# UDON SOUTH SITE DEVELOPMENT PLAN 12265 HIGHWAY 94

UDON SOUTH - PCD FILE # PPR2422

# V\_2 Site Development Plan.pdf Markup Summary

3 CHAIN LINK FENCE
NTS

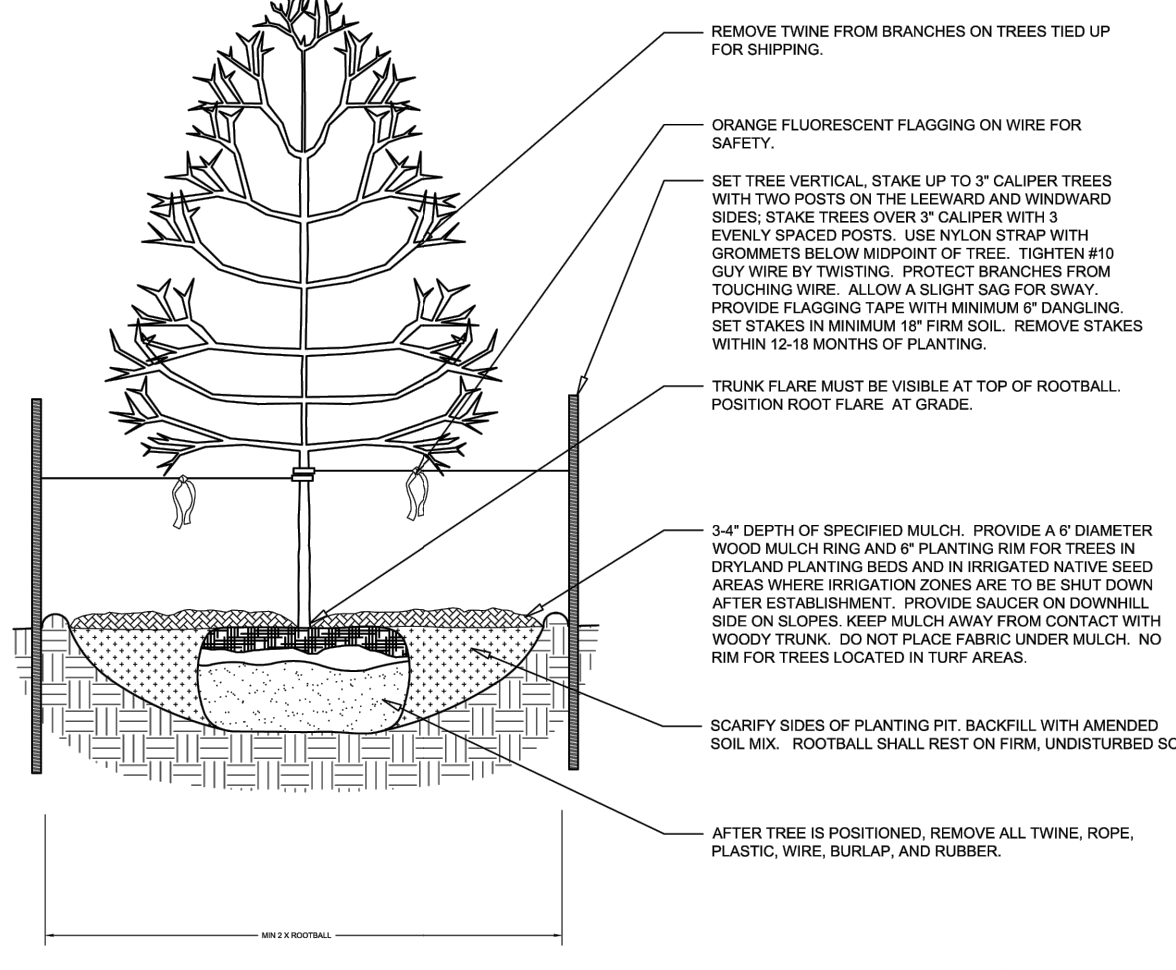
You have shown on one fence line that it is the top of landscaping berm. Are all fences on top of berms? How high are the berms? What type of fence material are you using?
